# Claremont Business Park 2 Filing No. 1 ). 3

## STREET IMPROVEMENT PLANS (INCLUDING STORM SEWER)

STREET IMPROVEMENT PLANS	
PROJECT NO. 44-037	DATE: 04/28/2020
DESIGNED BY: GW	HORIZONTAL: N/A
DRAWN BY: CLP	VERTICAL: N/A
CHECKED BY: VAS	SHEET 1 OF 12
S101

CLAREMONT BUSINESS PARK 2 FILING NO. 1	
STORM SEWER PLAN & PROFILE	
PROJECT NO. 44-037	DATE: 10/15/2020
DESIGNED BY: GW	SCALE: HORIZONTAL: 1"=50' VERTICAL: 1"=5'
DRAWN BY: CLP	SHEET 6 OF 12
CHECKED BY: VAS	ST02

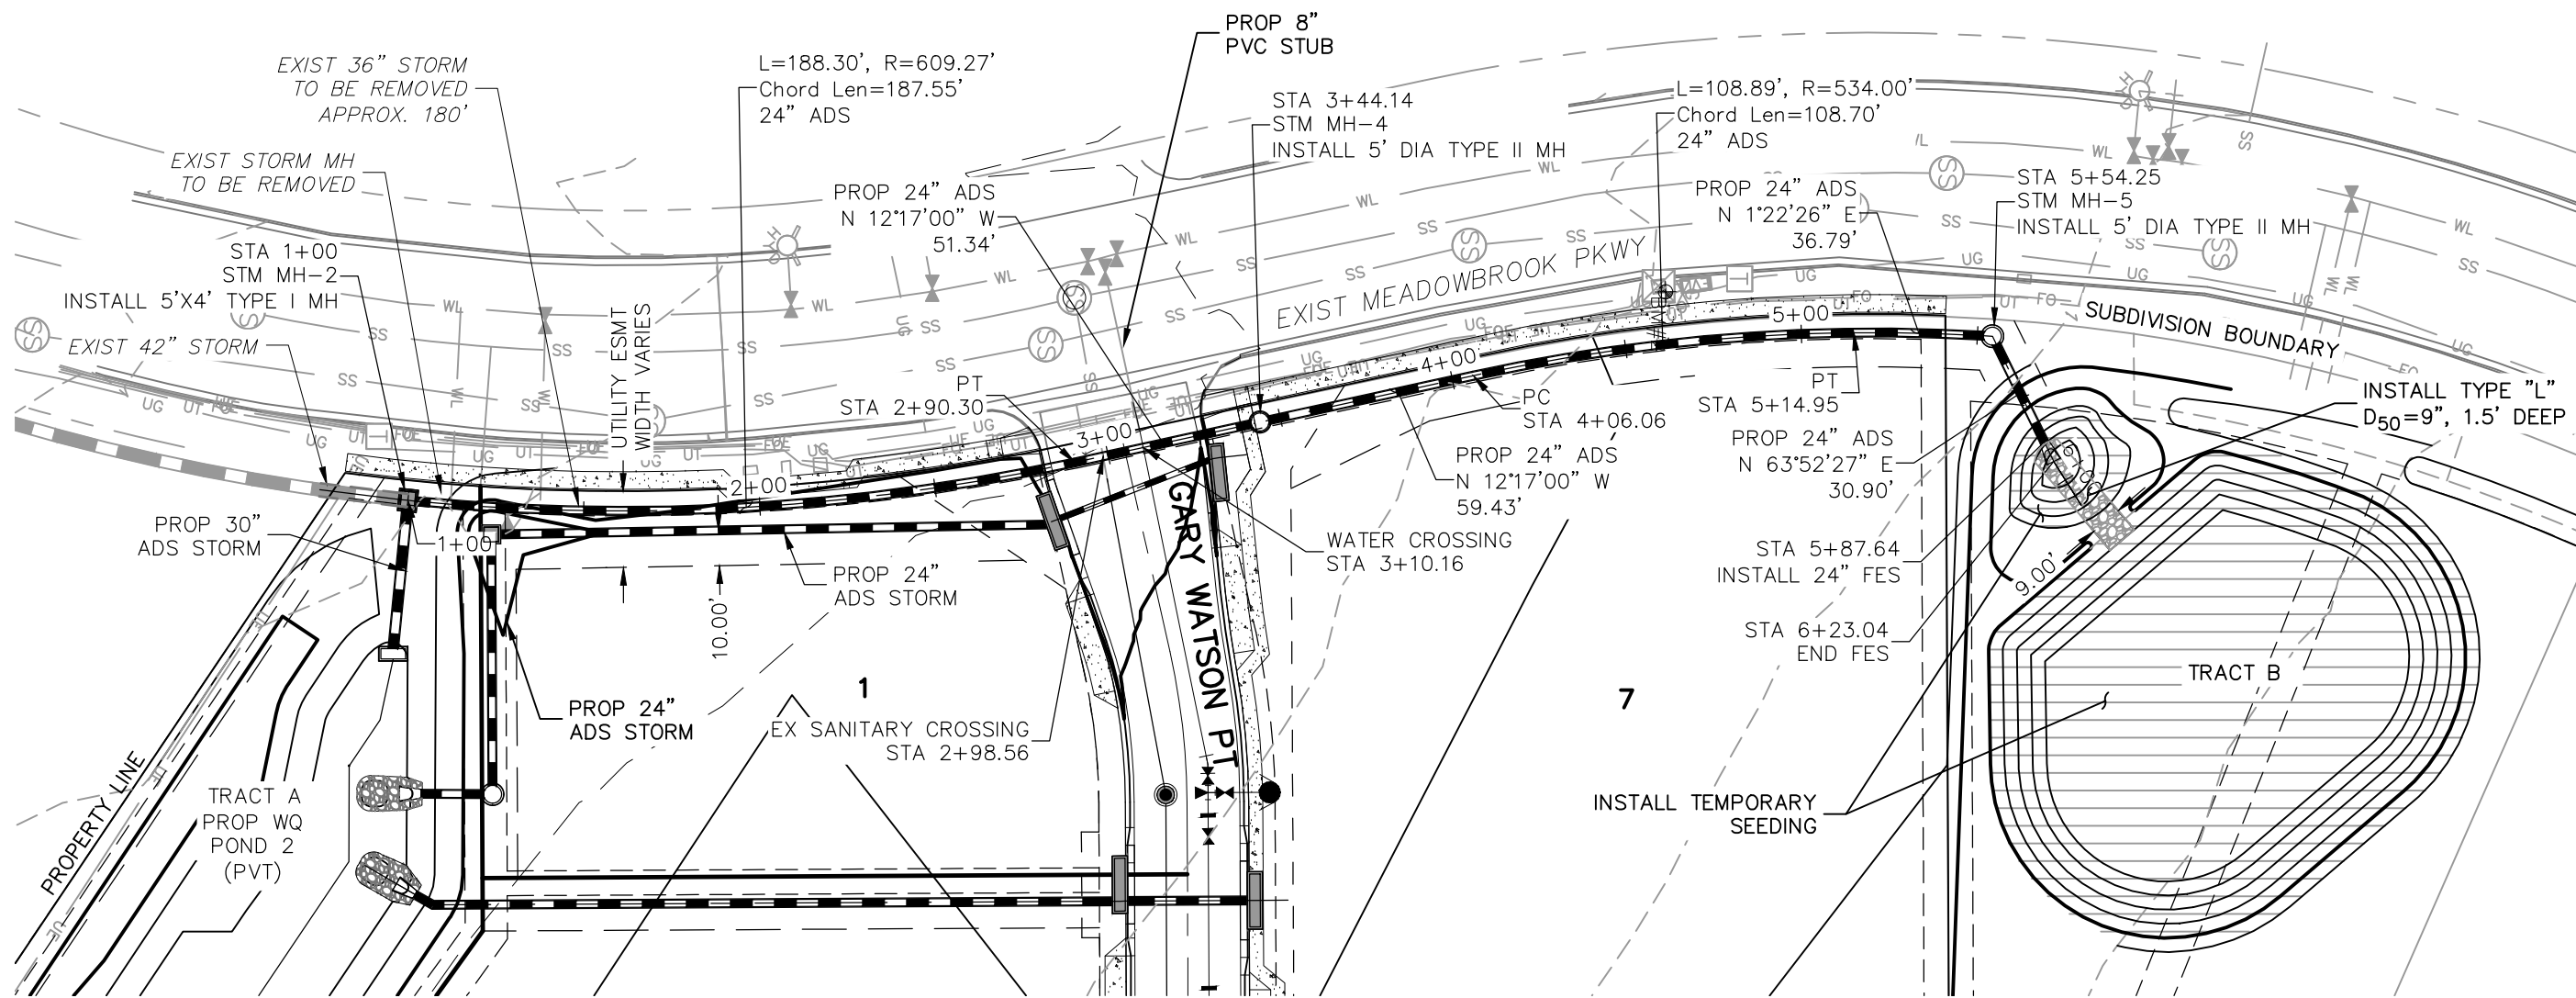
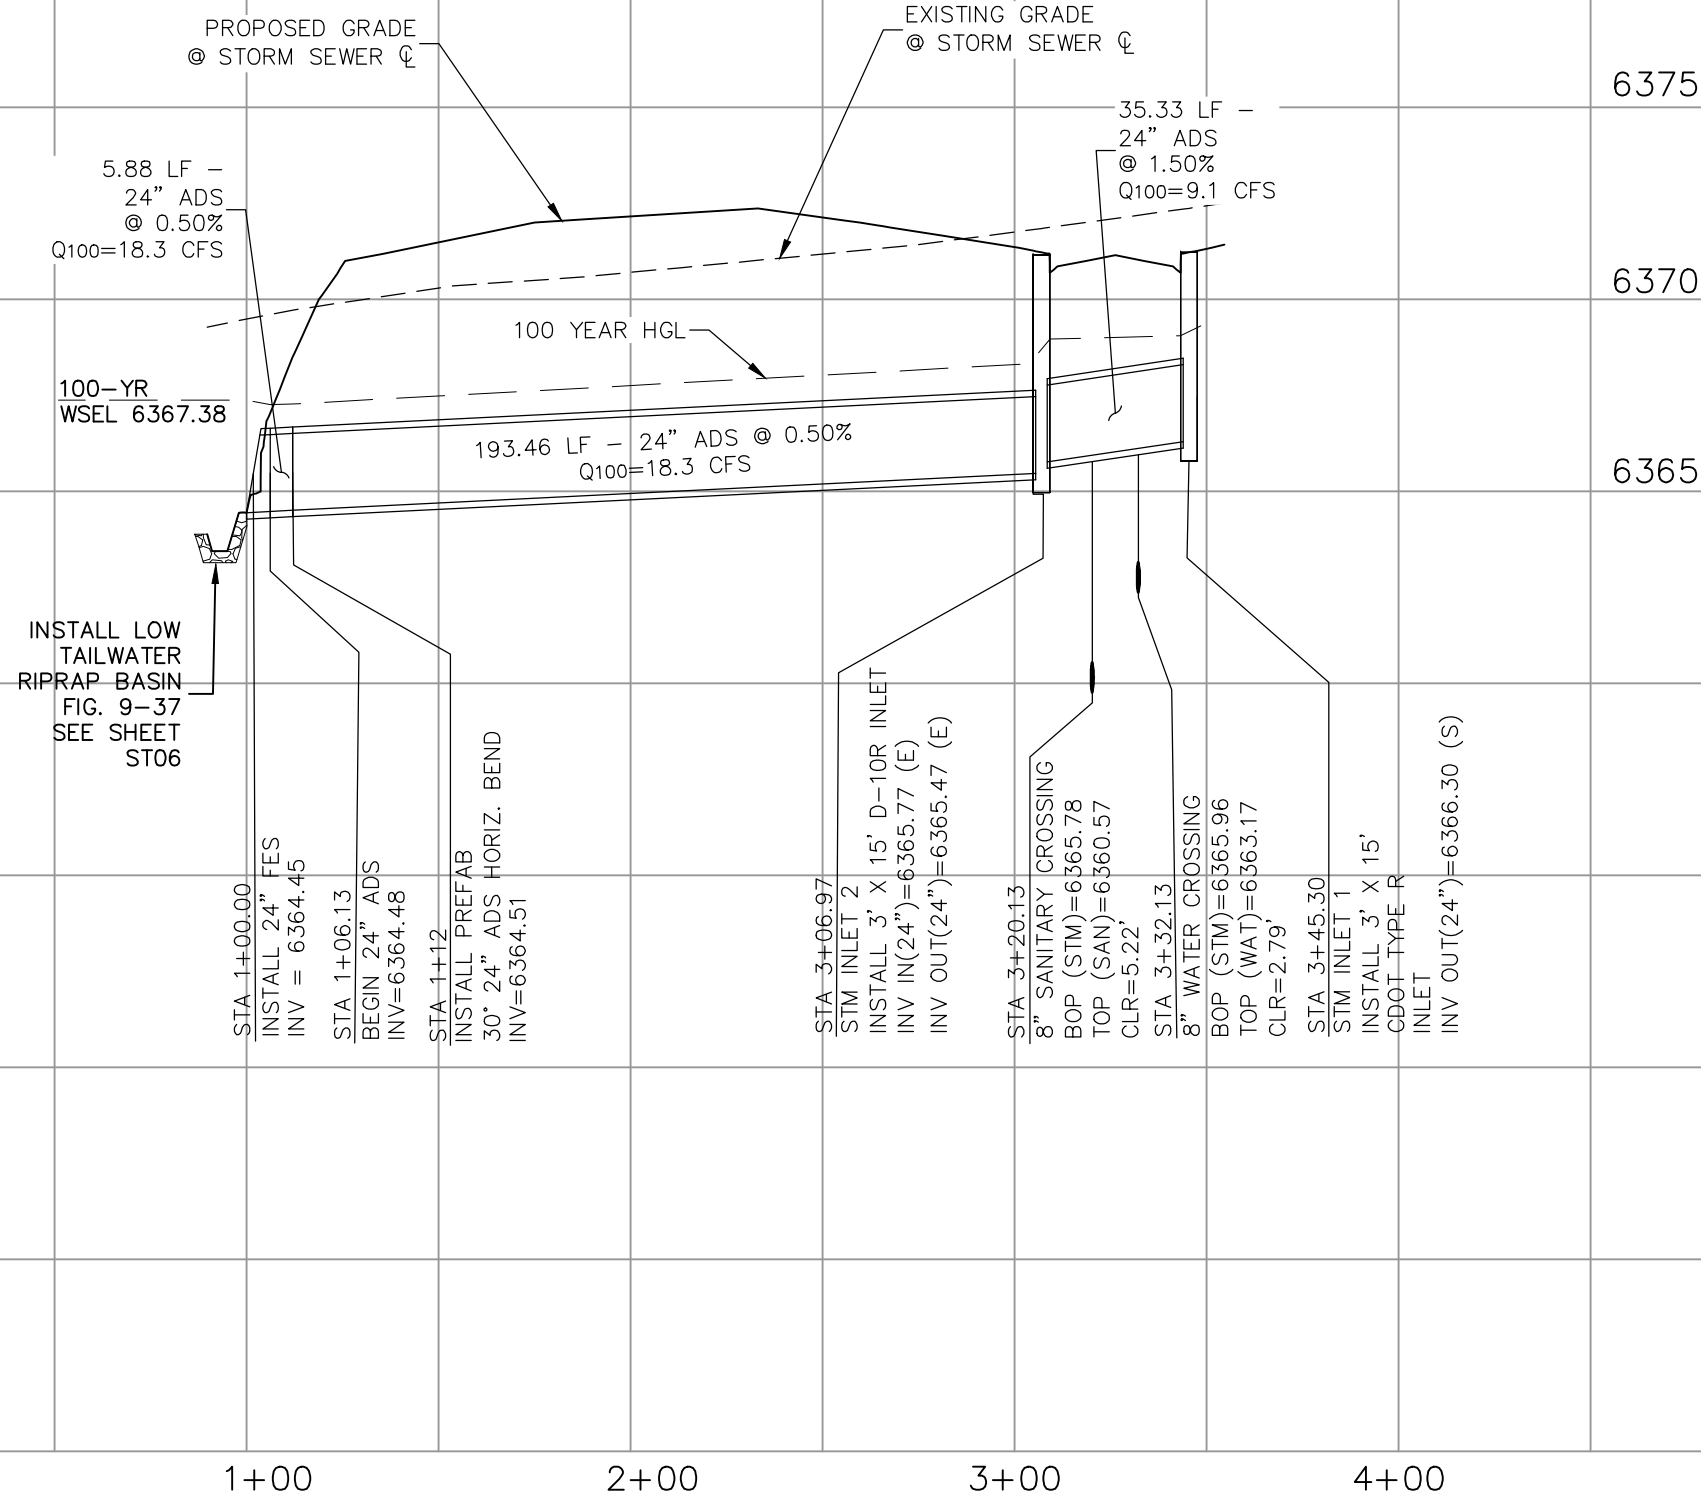
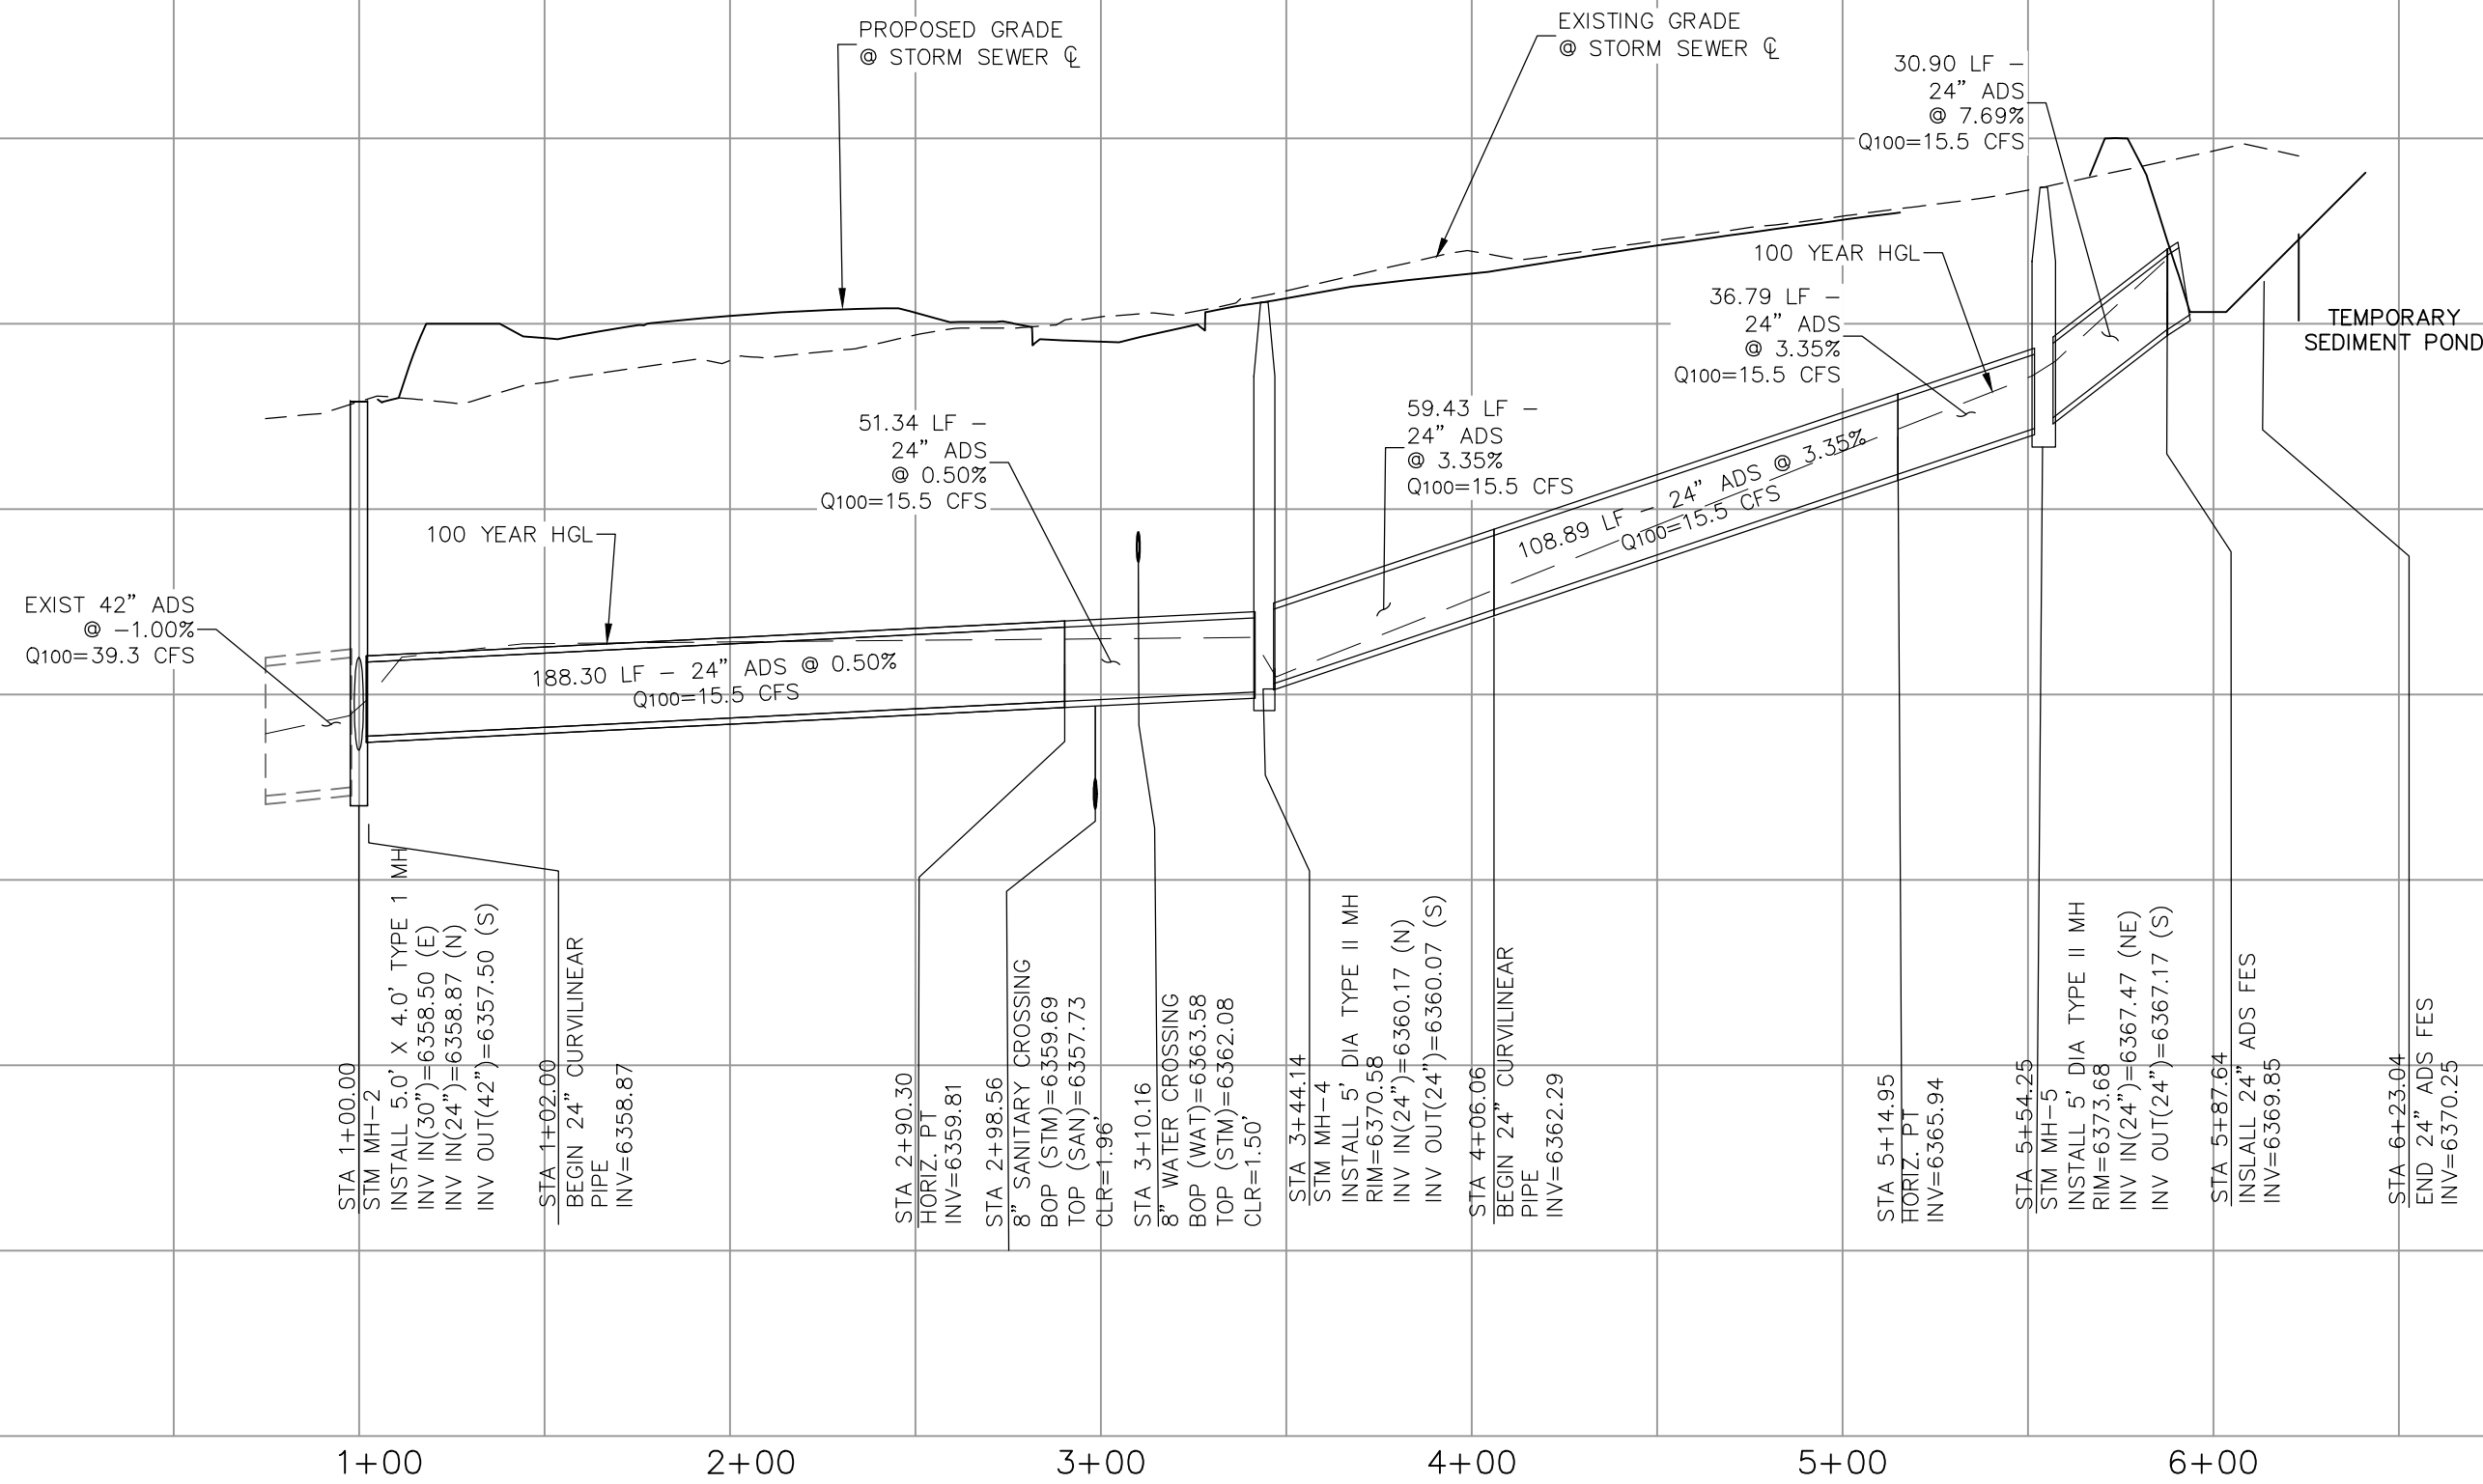
The drainage plan indicates a 36" storm sewer to be removed. Revise accordingly.

The drainage plan indicates 30". Revise accordingly.

30" is shown on the drainage plan. Revise accordingly.

24" is the correct sized drainage Plan has been revised

24" is the correct sized drainage Plan has been revised
